From: Zac Denton
Sent: 24 July 2019 08:25
To: Planning Scanning
Subject: FW: Previous objections and enquiries.
Attachments: image1.png; ATT00001.txt

Cc:**Sent:** Thu, 20 Jun 2019 at 12:10**Subject:** Planning App AB39 19 PL and
AB40 19 PL Objection

SURVEY - GROUND FLOOR PLAN

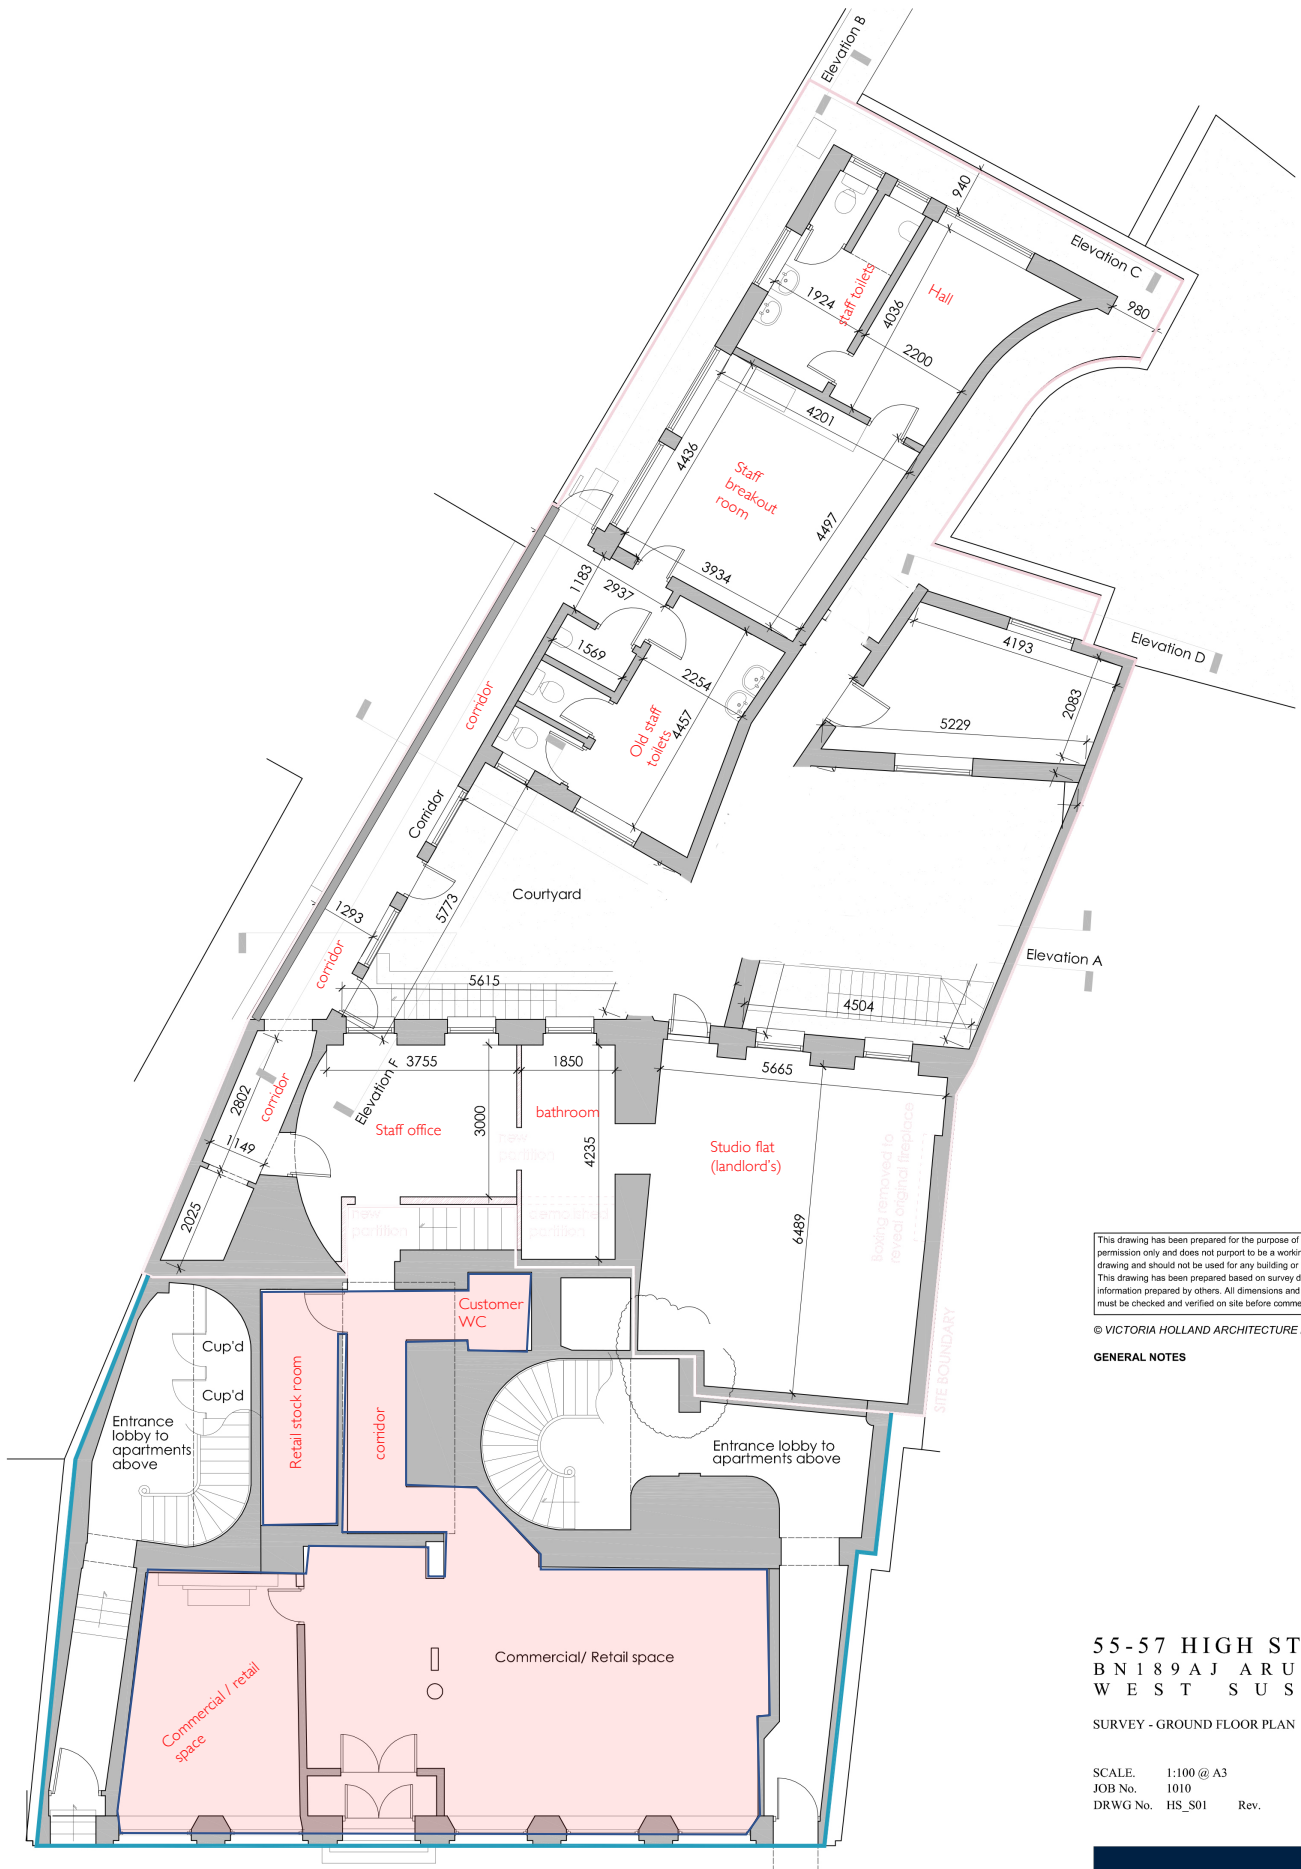
In relation to the 2 applications mentioned in the subject header, the plans need to be re-submitted clearly outlining the demarcation internally (floorplans) and externally (courtyard) between residential and commercial usage. I should also like to enquire that if the changes are approved how the noise levels between both areas are to be controlled and also how this should effect the homes above the commercial areas?
